From: Zac Denton
Sent: 06 September 2017 15:16
To: [REDACTED]
Subject: EP/98/17/CLP

I was looking at the plans for your application EP/98/17/CLP and I think one of the scales may appear wrong. At the top of your plan (drawing number – 1104.02.a) it states that the scale for the elevations is 1:100. This would mean the extension is over 6m high!

| Revisions                                                                                                                                                                                                                                                         |                        |    |
|-------------------------------------------------------------------------------------------------------------------------------------------------------------------------------------------------------------------------------------------------------------------|------------------------|----|
| Drawing Number: 1104.02.a                                                                                                                                                                                                                                         |                        |    |

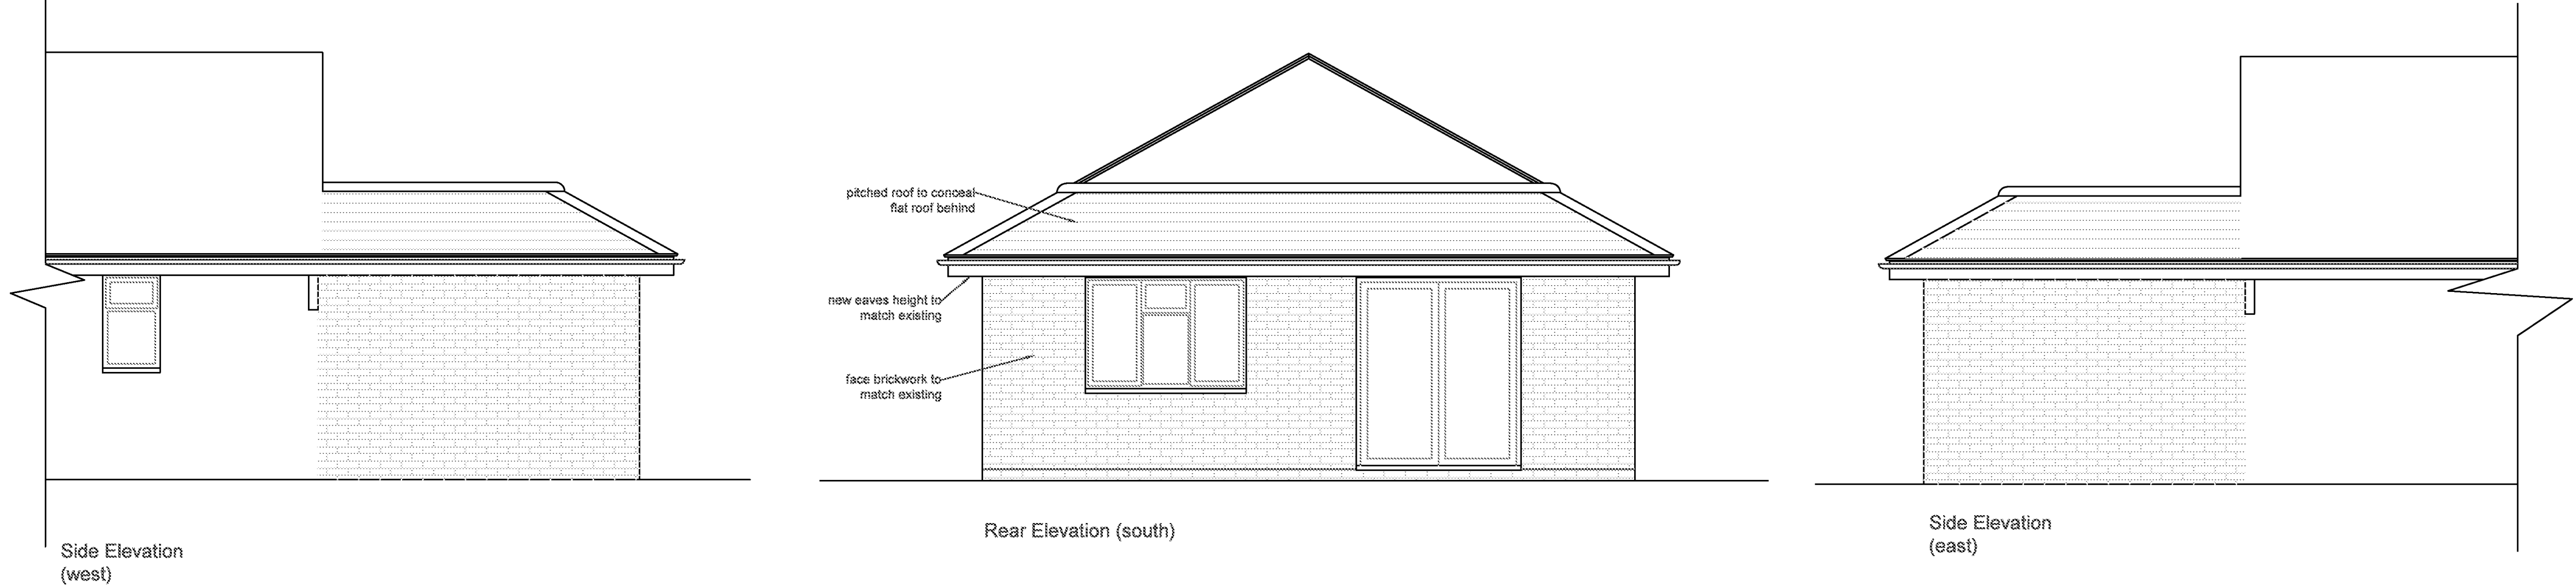
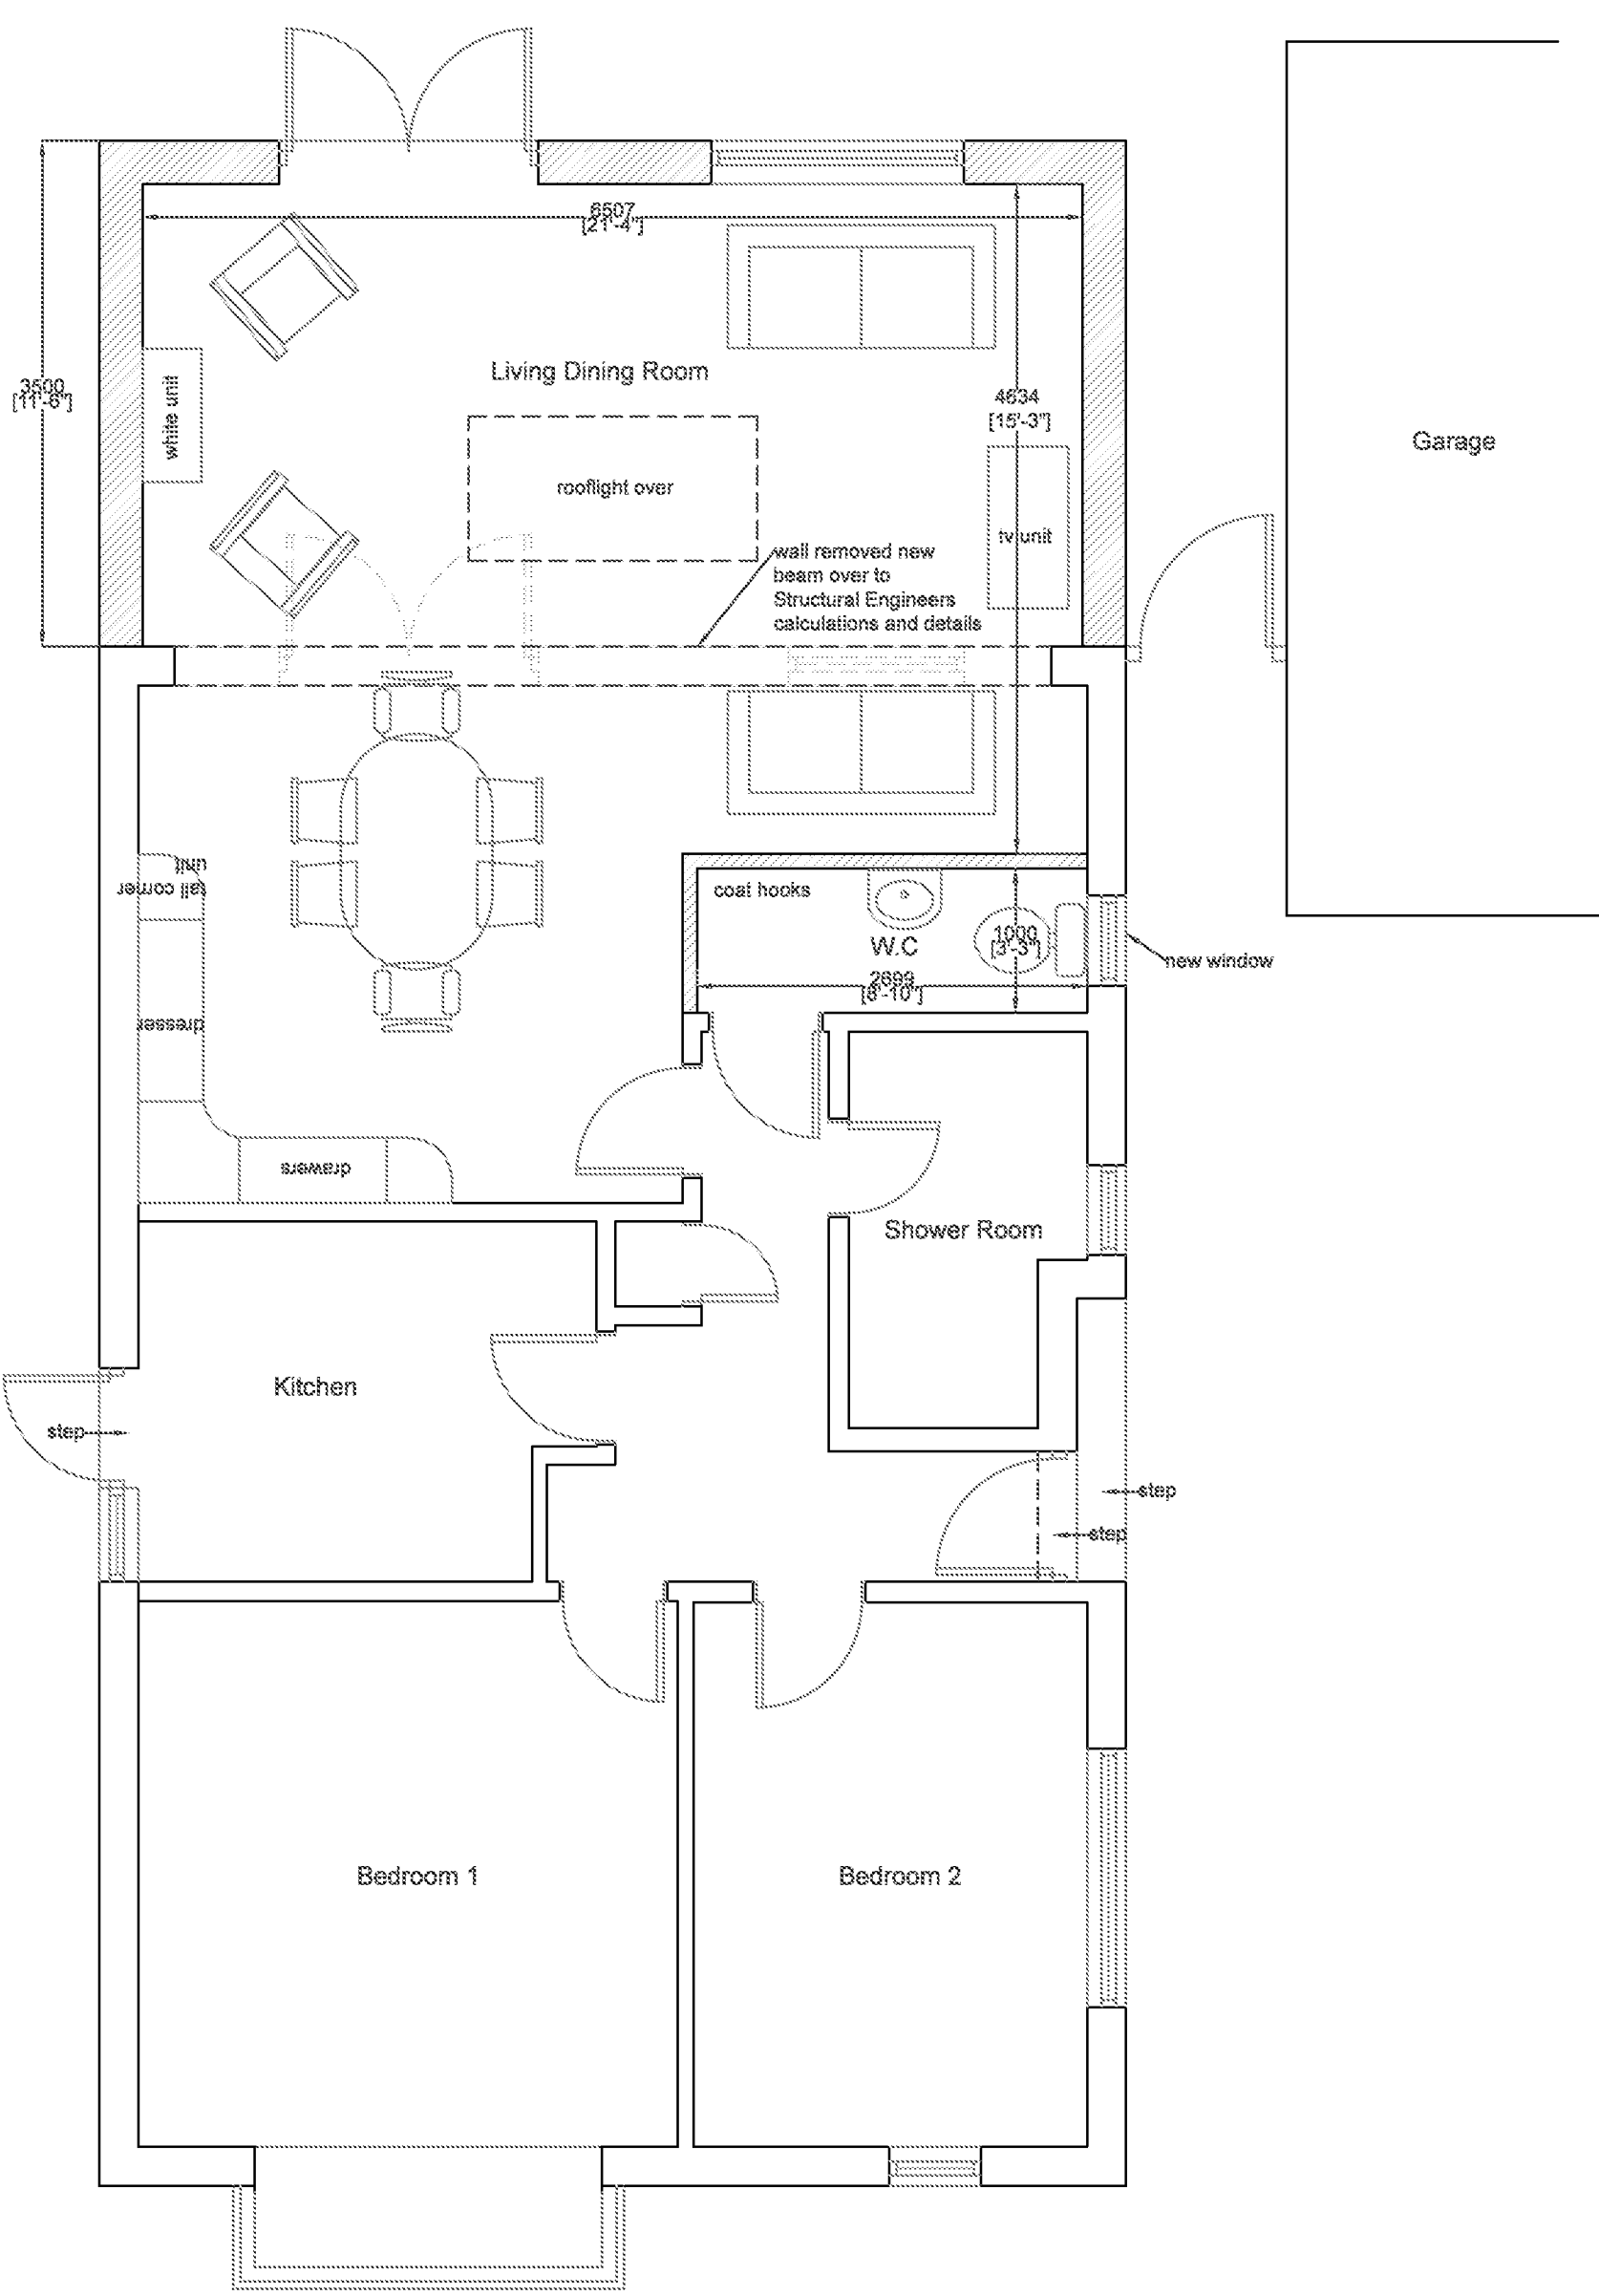
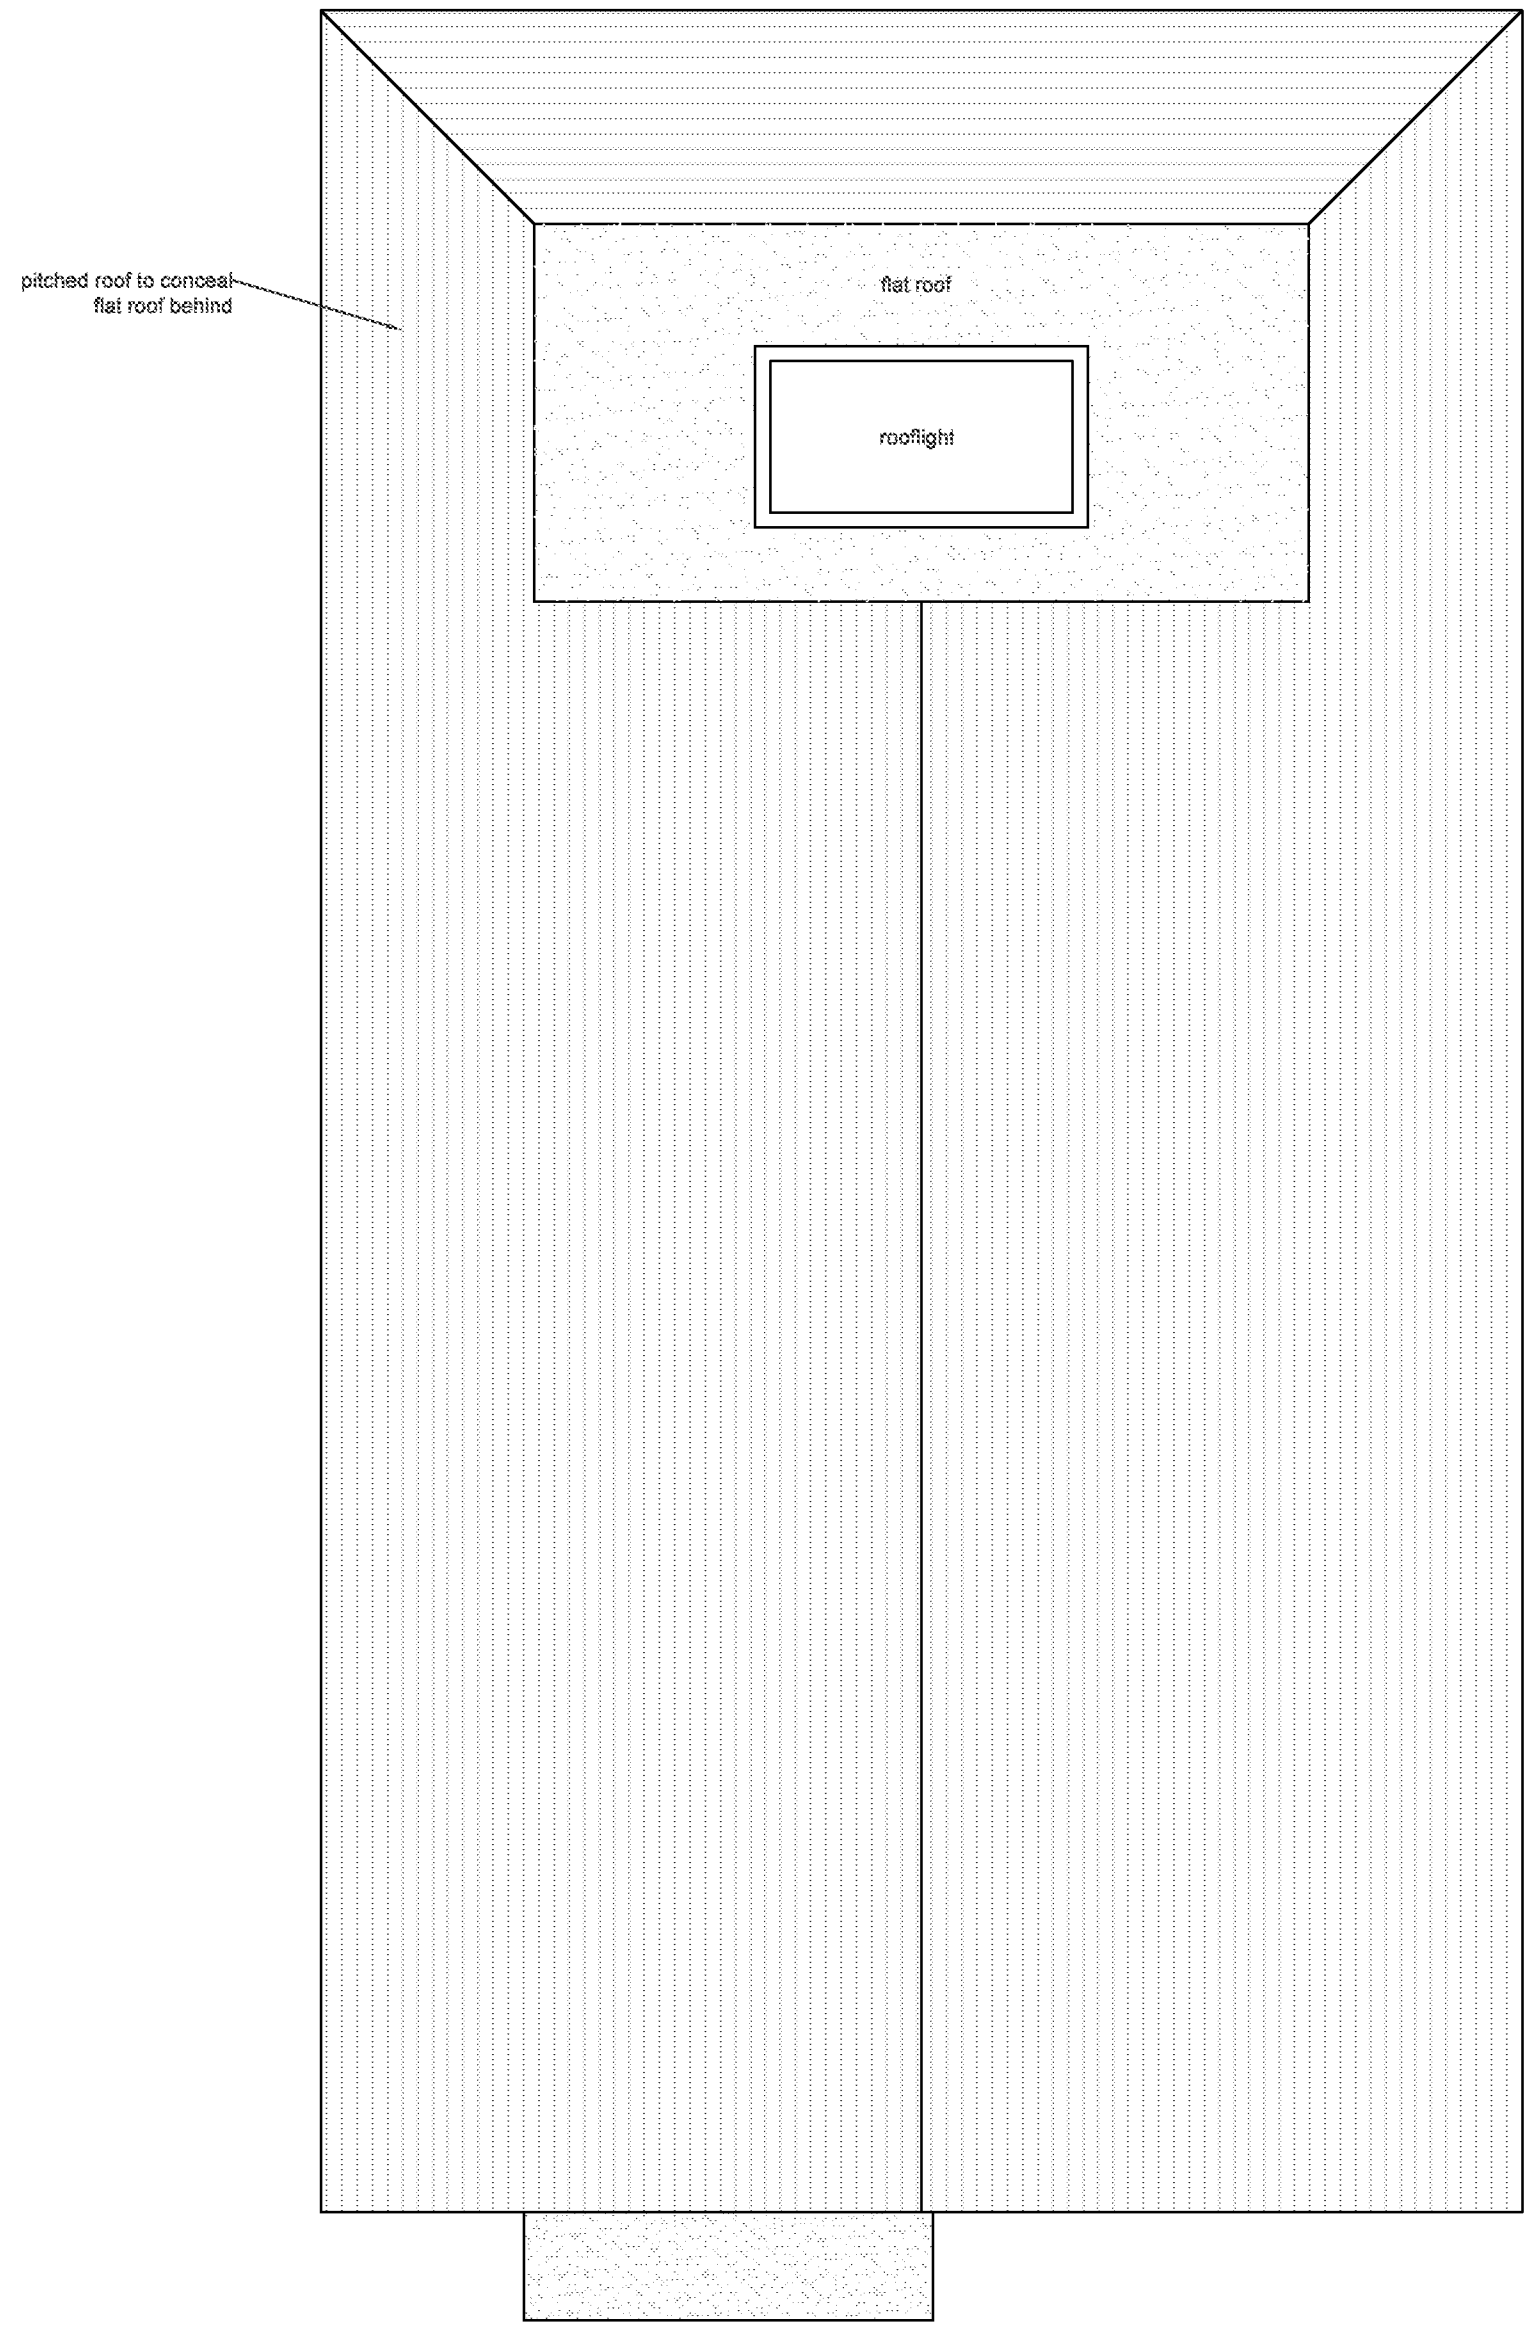
If it is incorrect then please reply to this email with an amended plan. (I feel as if the correct scale may be 1:50)
